Our reference: ECM 9090174
Contact: Gavin Cherry
Telephone: (02) 4732 8125

24 April 2020

Re: SSD 10448 – Request for Advice on Proposed Aspect Industrial Estate at 864-882 Mamre Road Kemps Creek

Figure 39 – General Arrangement Plan 1:5,000 [Source: AT&L Engineers]

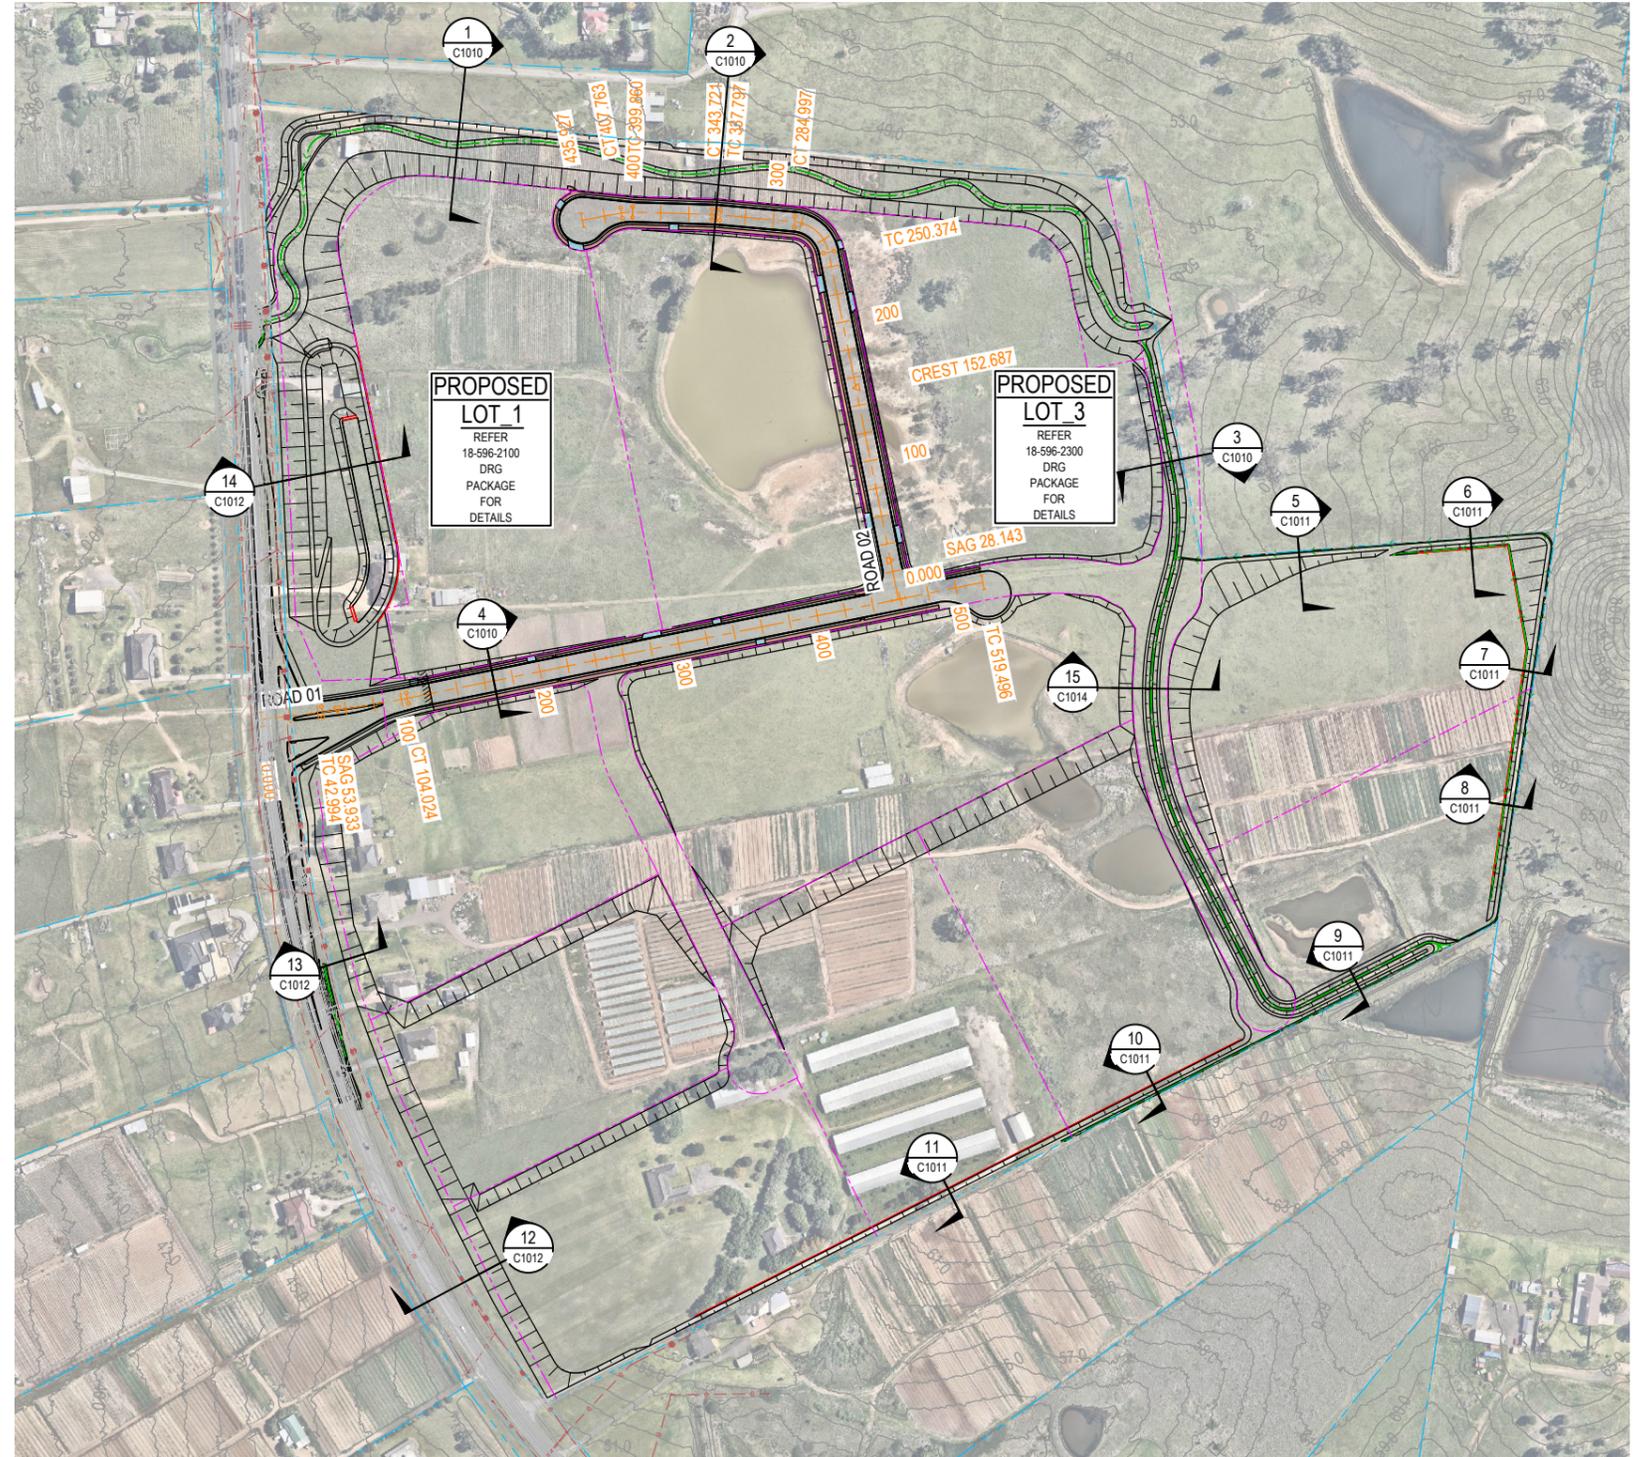
- In addition, the plan indicates a recreation area hatched in front of Proposed Lot 1 but it is not clear what this is. This requires further consideration and discussion.

- The plans suggest a riparian area in the north western corner of the site however the drainage infrastructure by virtue of a basin and swale is not a naturalised riparian outcome. The development must treat an existing riparian corridors as such to ensure the outcome is naturalised and to WaterNSW / NSW Natural Resources Assess Regulator requirements. Alternatively, if this is not a riparian corridor and is for drainage infrastructure, the landscape design must ameliorate the impact and presentation of that infrastructure.

- The indicated swale and basin within the front setback and northern side setback may compromise necessary landscape design and planting outcomes for the streetscape and resulting public domain interface. The stormwater management strategy and landscape design scheme must be considered in combination and demonstrate a suitable public domain and edge interface outcome.

- While the red setback line is 7.5m for the most part, the green setback line did not appear to be dimensioned. Further the red setback line at Lot 8 appears to be 5.0m and not 7.5m. A consistency in established setbacks is critical between the built form and property boundaries, as well as car parking and property boundaries. While Council would encourage 7.5m setback to all works (building and car parking), allowance down to a minimum of 4.0m may be reasonable, subject to the landscape design detail being submitted. As Access Road 1 is the principal entry road into the estate, an embellished landscape design (7.5m min setback) would be encouraged. Lower order side streets could adopt less setbacks to no less than 4.0m. This detail must be addressed within a site specific DCP or a precinct wide DCP having regard to the mass of the intended built form, the finished ground levels, the necessity for any retaining walls or other structures in the front setback zones and signage.

- Duplicated service driveways next to roads should be deleted. Lot 9 adjacent to Road 1 provides a compromised landscape outcome that can be avoided by the deletion of the service driveway forward of the 7.5m setback line.

- Lot 2 and Lot 3 should be amended to ensure all car parking is outside the 7.5m setback line to the front boundary of Access Road 2. The
